**KIRKLEES METROPOLITAN COUNCIL
INVESTMENT & REGENERATION SERVICE**

DELEGATED DECISION TO DETERMINE PLANNING APPLICATIONS

Reference No:	2025/62/93472/W
Site Address:	2, Newland Avenue, Birkby, Huddersfield, HD2 2UU
Description:	Erection of replacement garage and installation of solar panels to dwelling with associated alterations (within a Conservation Area)
Recommending Officer:	Jennifer Booth

DECISION – REFUSED

Front Elevation SE Showing Solar Panel and Portico  
1 : 100

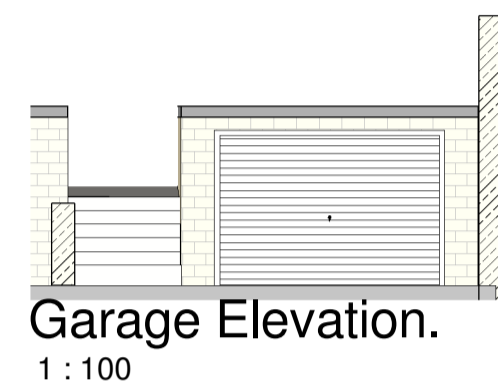
The proposal includes the erection of a portico to the front elevation of the property. The portico has a lightweight appearance with a roof form set on posts. This part of the scheme would comply with the requirements of the SPD by the house being set well-back from the pavement; the extension being small and subservient and; not unreasonably affecting neighbouring properties. It is not considered that the portico would have an unacceptable impact on the host dwelling, the street scene or the Conservation Area. Therefore, it is considered that this part of the scheme would comply with policies LP24 and LP35 of the Kirklees Local Plan, as well as Chapter 12 and Chapter 16 of the NPPF.

The number of panels proposed is not clear although the plans demonstrate that they would be installed on the front and rear elevations of the property.

There is no reference to the impact of solar panels within the immediate vicinity of the site within the Heritage Statement however, subject to conditions requiring the panels to be constructed using black glass and black frames and removed when no longer in use it is considered that whilst a level of harm would

Garage Elevation  
1 : 100

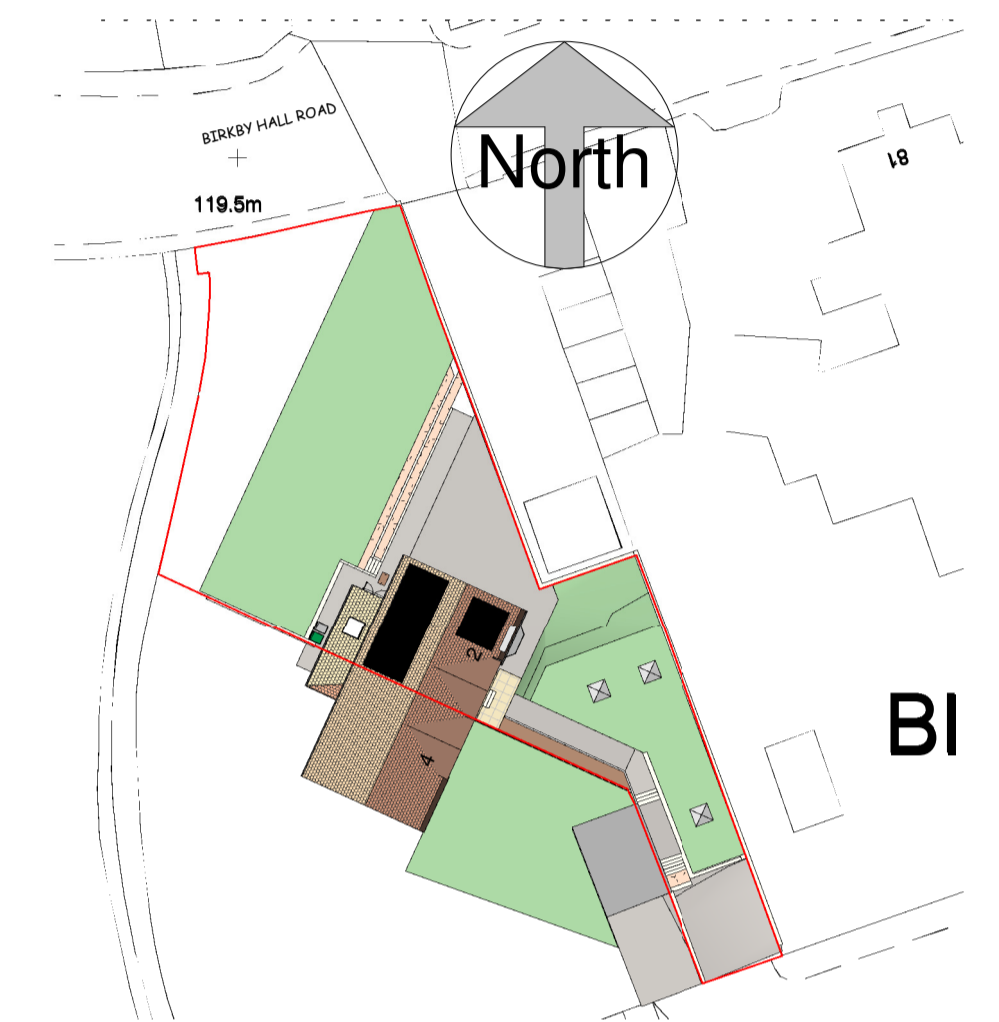
Whilst the replacement garage would be located in the same position as the exiting garage, it would be much larger than the existing in terms of size and scale. The proposed garage would have a depth of approximately 16 metre with the widest width point being approximately 10 metres. Due to the location of the garage, which is accessed off Newland Avenue, it would not be possible to comply in totality with the SPD in so far as being set back from the building line.

Whilst it is noted that with the Heritage Statement that the garage would be in part below ground level a large amount of excavation would be required to accommodate the development with associated retaining structures. The development would incorporate means of enclosure upon the roof of the large outbuilding to front. The size and scale of the proposed building would not be proportionate to the size of the host dwelling. This would be further exacerbated with the introduction of astro turf to the roof and the means of enclosure constructed upon the roof.

The means of enclosure would consist of a wall constructed to a height of 1.2 metres above the elevations of the proposed building and which would be clearly visible from public vantage points which would be out of keeping with the host and surrounding properties.

The proposed garage and walling above would be visually dominant and unsympathetic to the host property, and their approval would result in less than substantial harm to the character and appearance of the Conservation Area.

1. The proposed garage, by virtue of its scale, massing, above and below ground works and design would form an large addition to the host dwelling, having a harmful impact upon the visual amenities of the host property, wider locality and the character of the Birkby Conservation Area. The development would lead to less than substantial harm for which no sufficient public benefits have been demonstrated or are considered to exist more generally. The development is therefore contrary to the Council's duties under the Planning (Listed Buildings and Conservation Areas) Act 1990, Policies LP24 and LP35 of the Kirklees Local Plan, principles within the Councils House Extensions and Alterations SPD and policies within Chapters 12 and 16 of the National Planning Policy Framework.
